**PREFERRED PROJECT REPORT  
MAJOR PROJECT APPLICATION NO. 08\_0118**

**PROPOSED RESIDENTIAL SUBDIVISION  
AT LOT 4 DP 876253 WILLOW AVENUE  
BOGANGAR (SHIRE OF TWEED)**

**AUGUST 2010**

PROPOSED EARTHWORKS AND
SITE CROSS SECTIONS

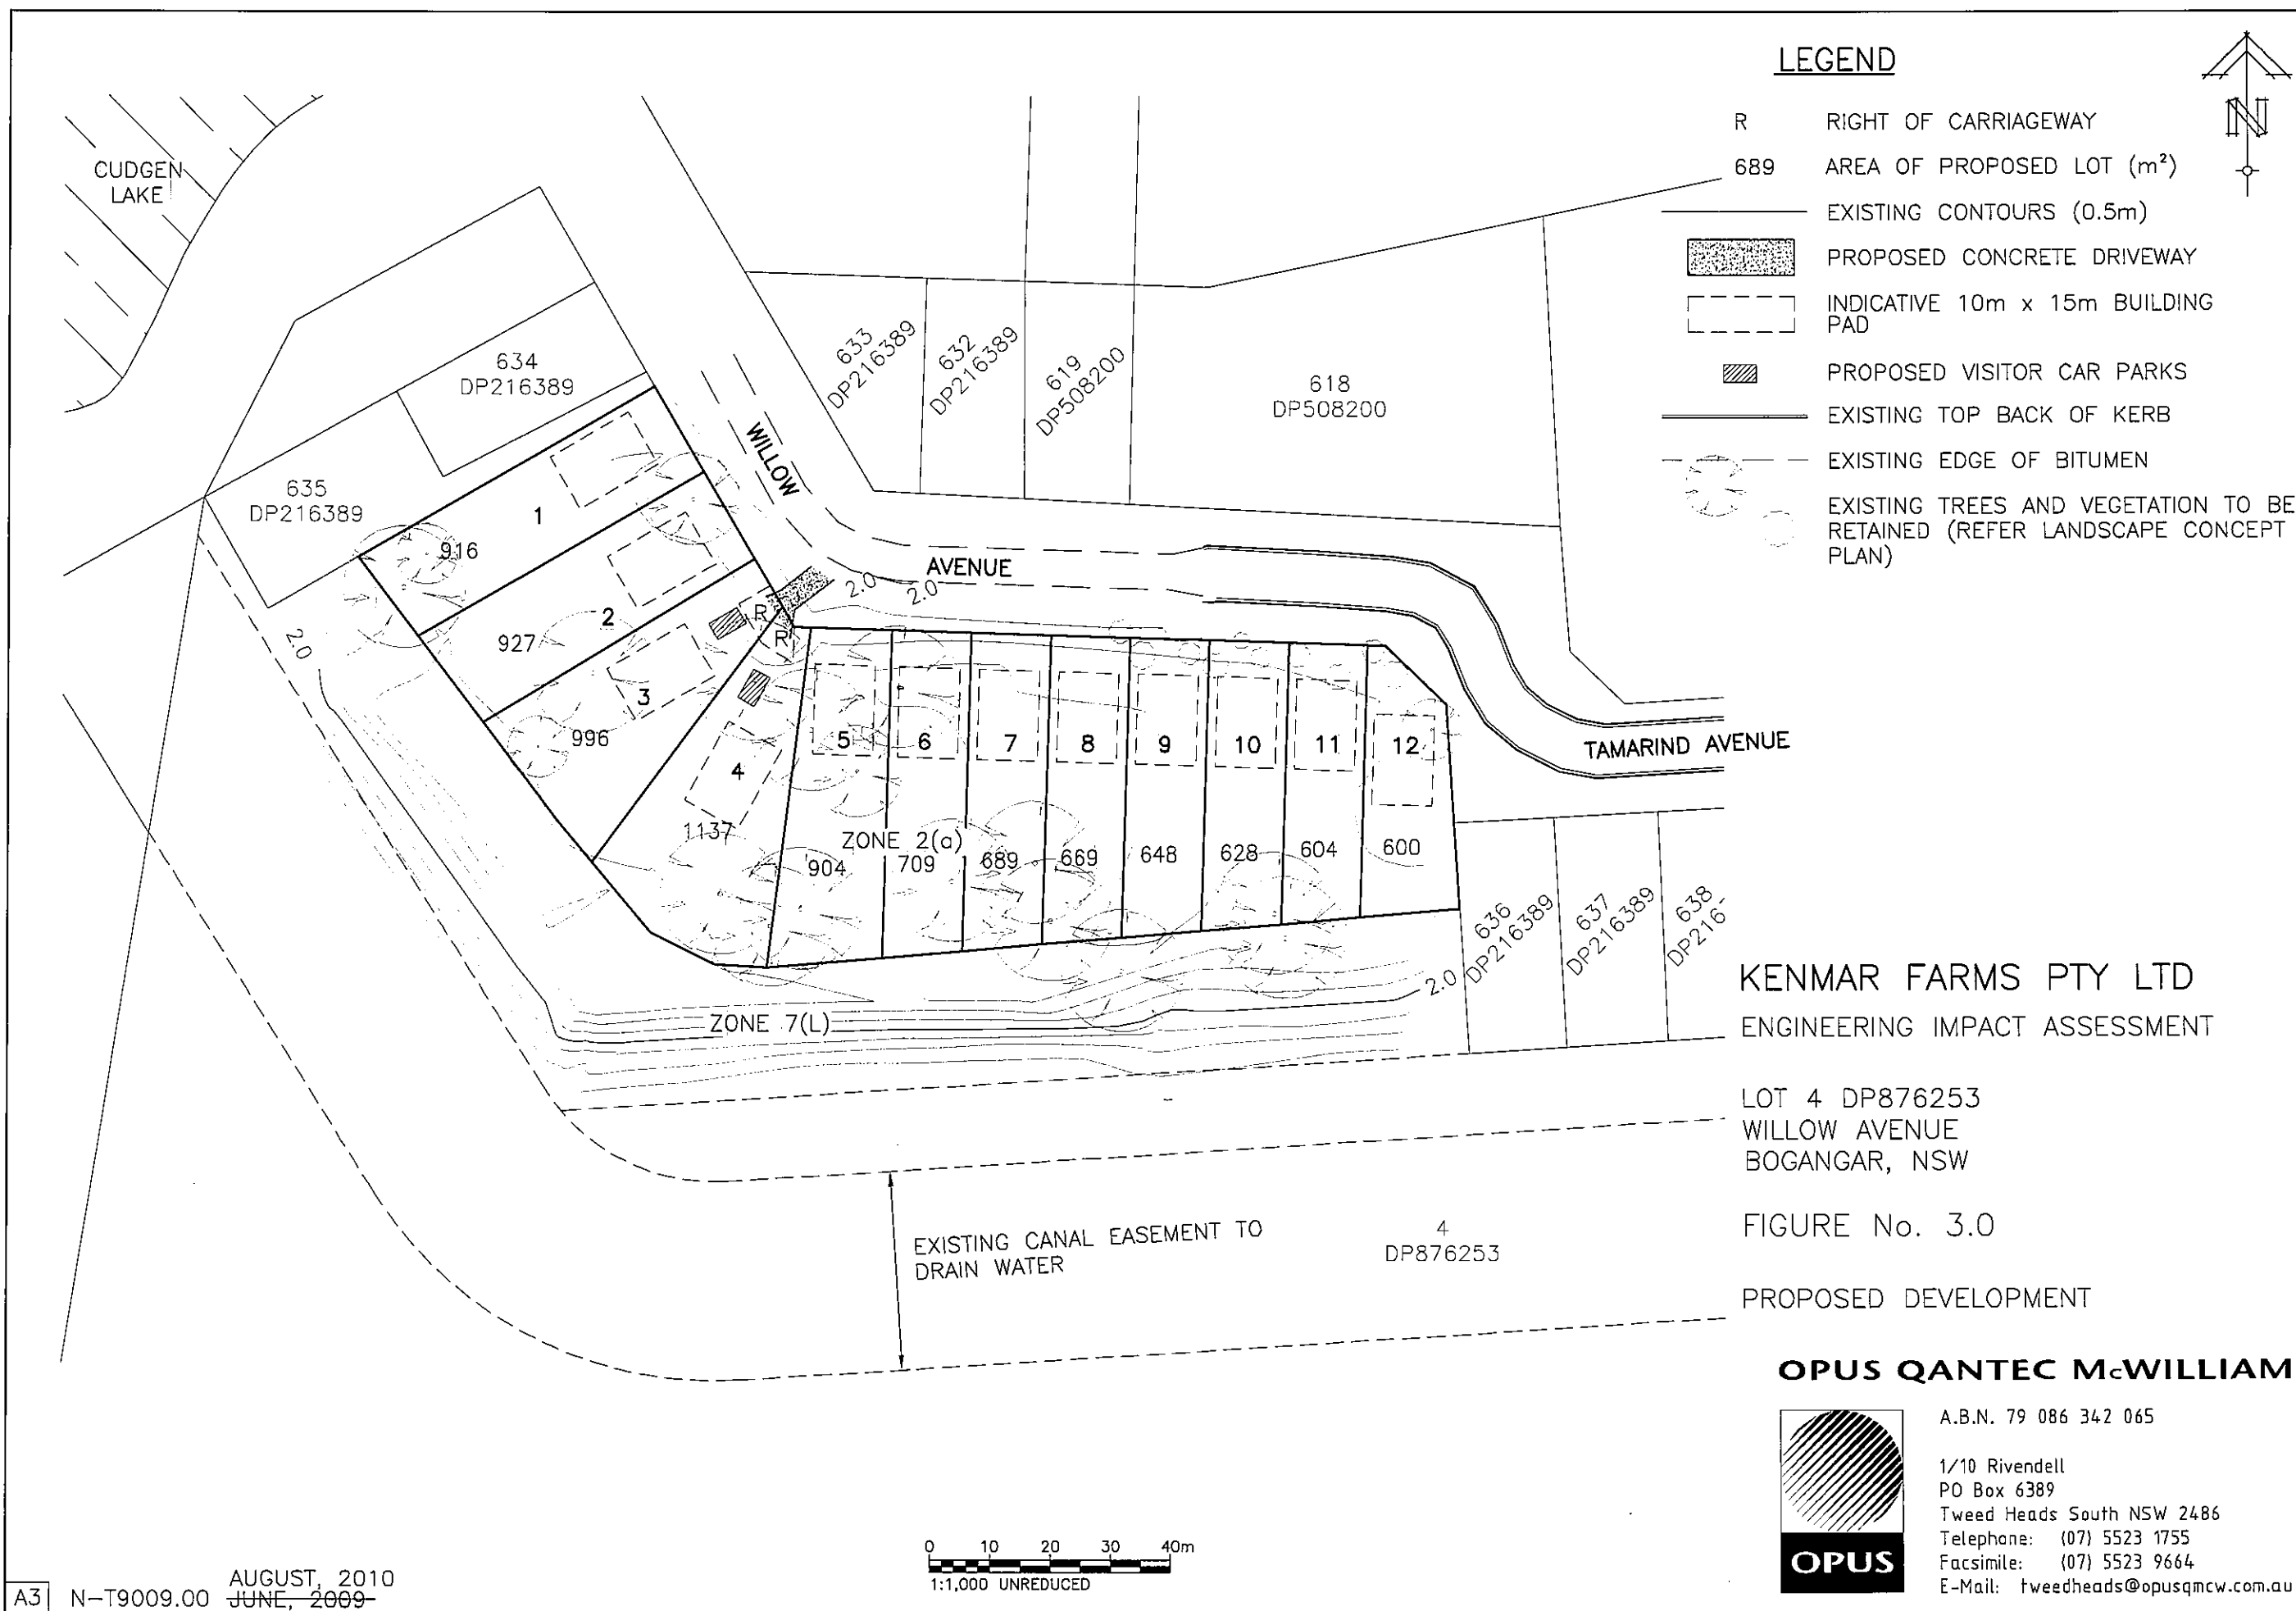
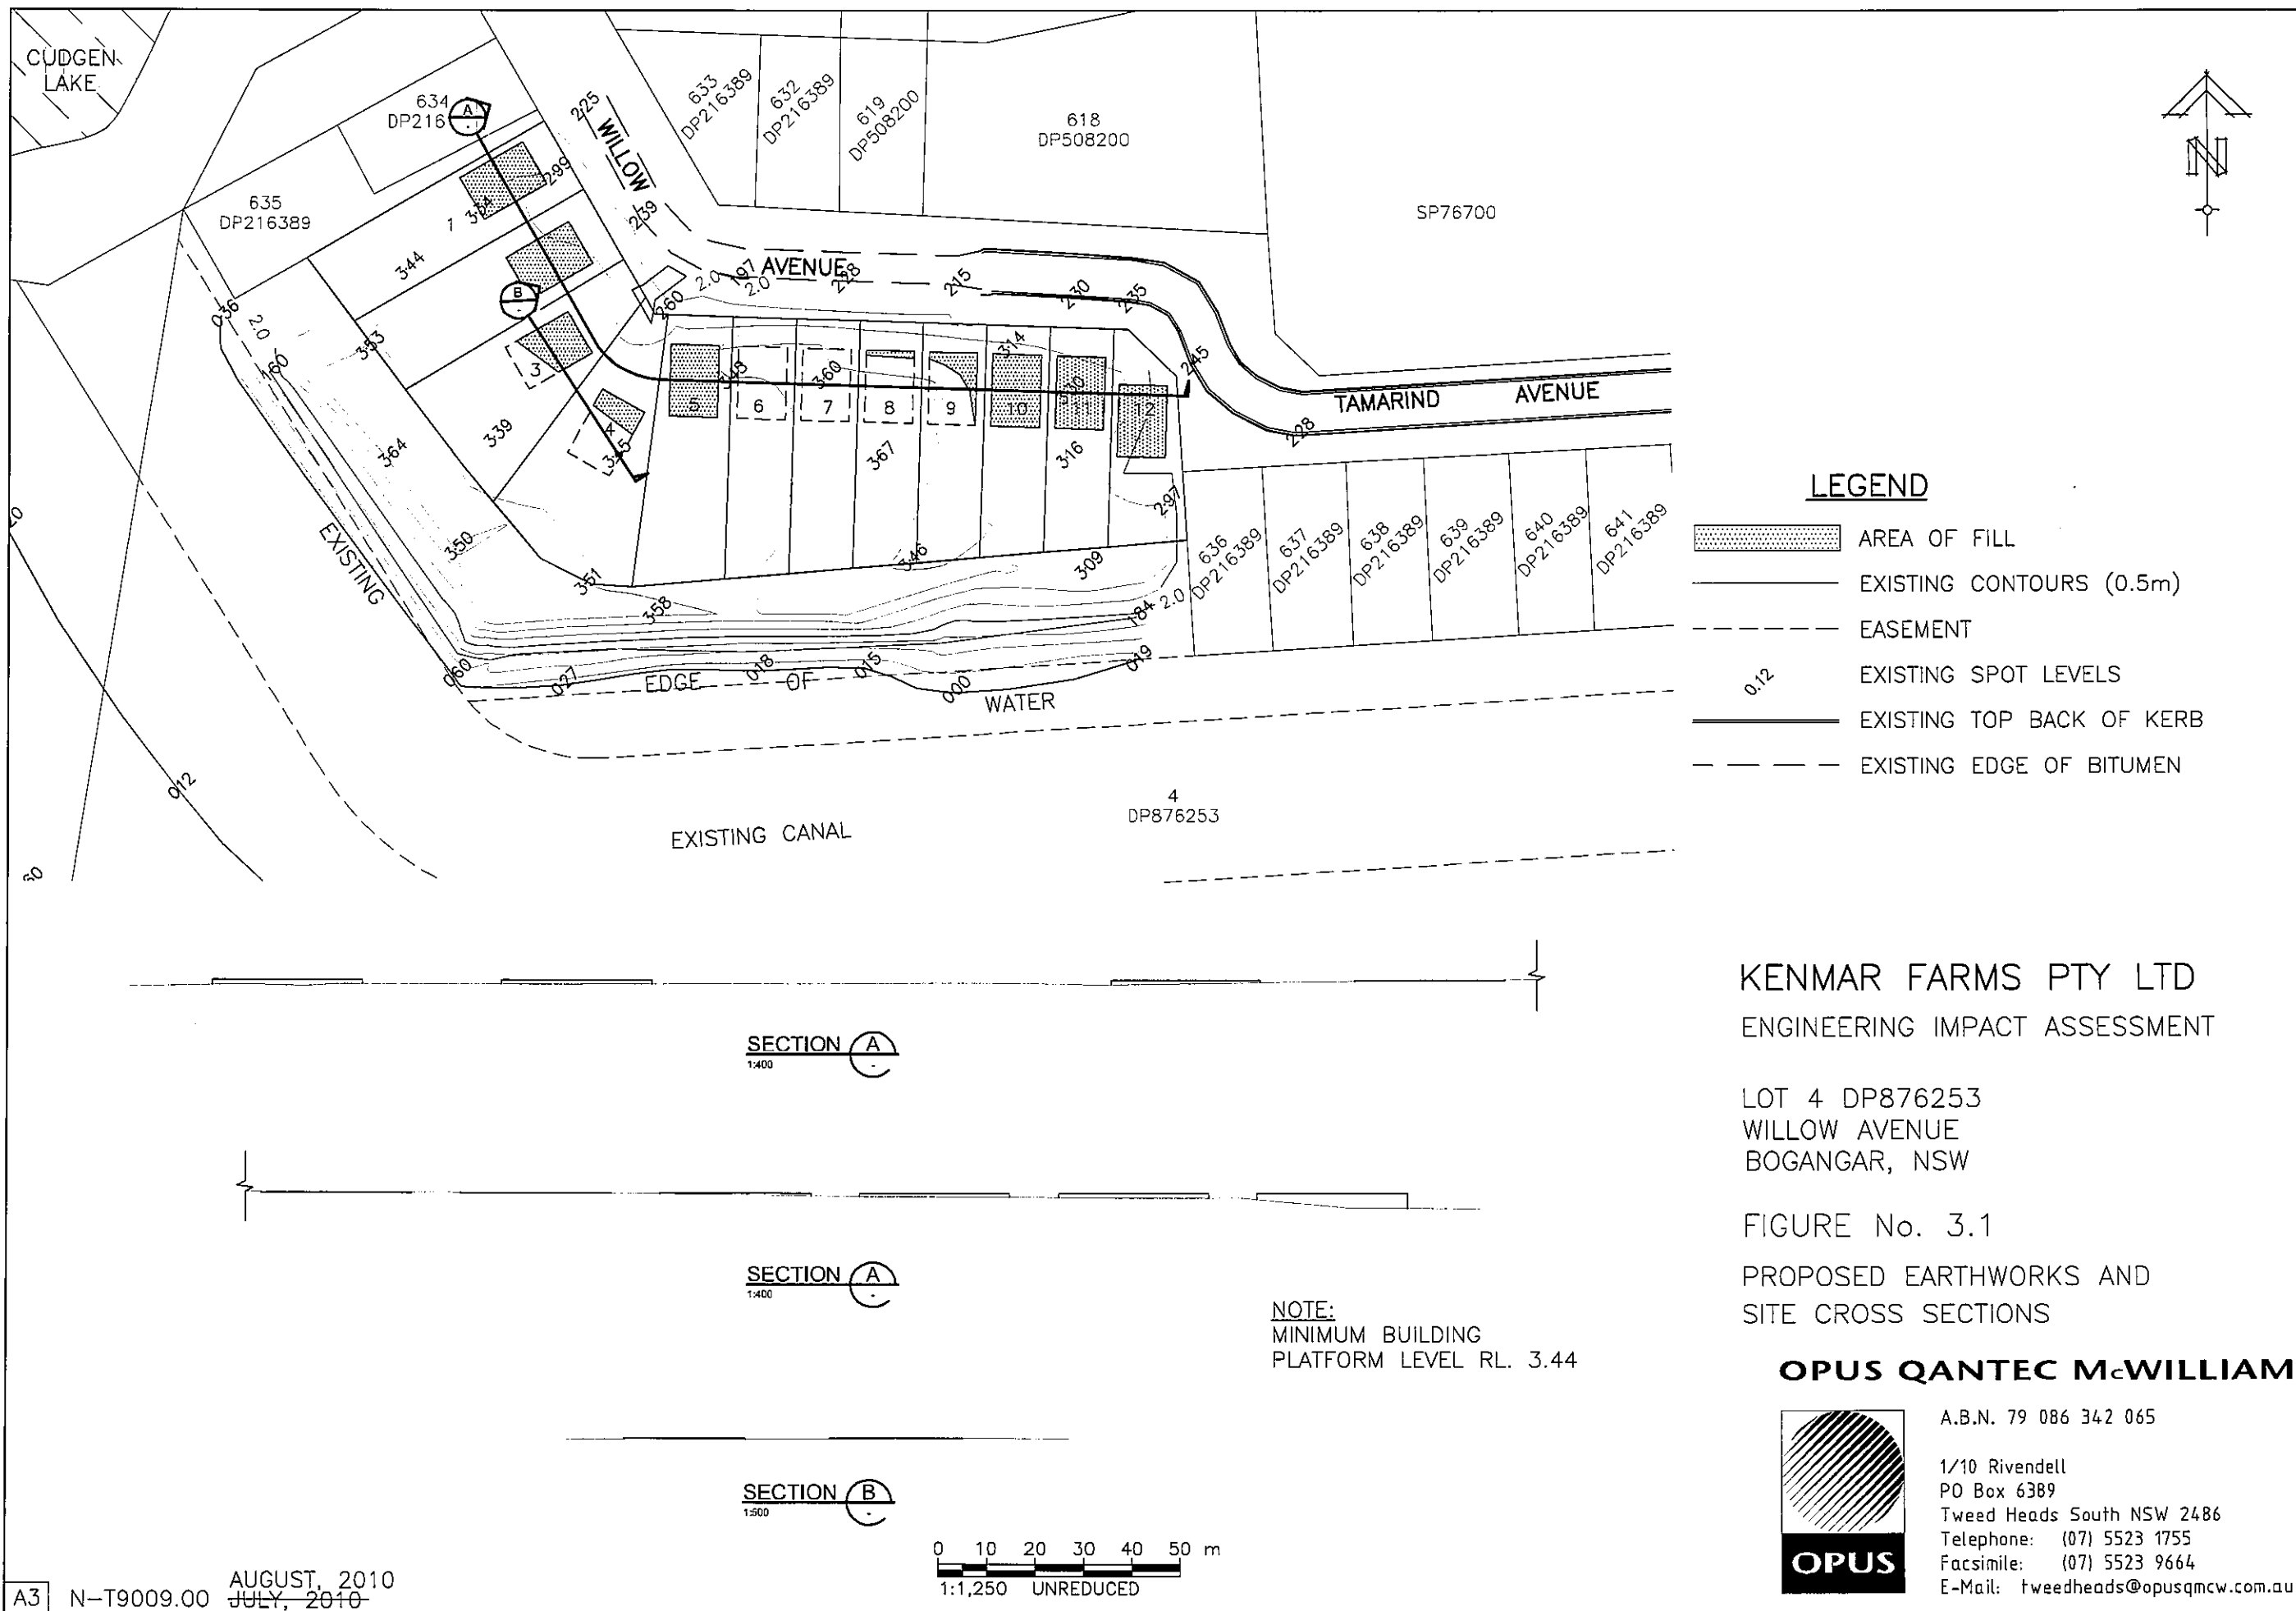
<b>Attachment 1</b>	
<p><b>1. Earthworks</b></p> <p>a. Provide a plan of earthworks proposed on-site that clearly indicates the levels and areas of cut/fill to achieve the appropriate flood level (in consultation with Tweed Shire Council as set out below). Provide documented evidence of your consultation with Tweed Shire Council in this regard. Provide cross-sections at the adjacent property boundaries to the east and west in order to demarcate any differences in levels (AHD).</p>	<p>Onsite earthworks are limited to house pads and minor earthworks to crate Tweed Shire Council compliant driveway access only. House pads will provide a minimum pad level of RL 3.44m in accordance with the revised flood modelling outlined in Item 2 below and freeboard of 0.5m. A proposed earthworks site cross-section plan has been included in the amended Engineering Impact Assessment Revision 1(EIA-R1) see <b>Annexure 2</b>.</p>
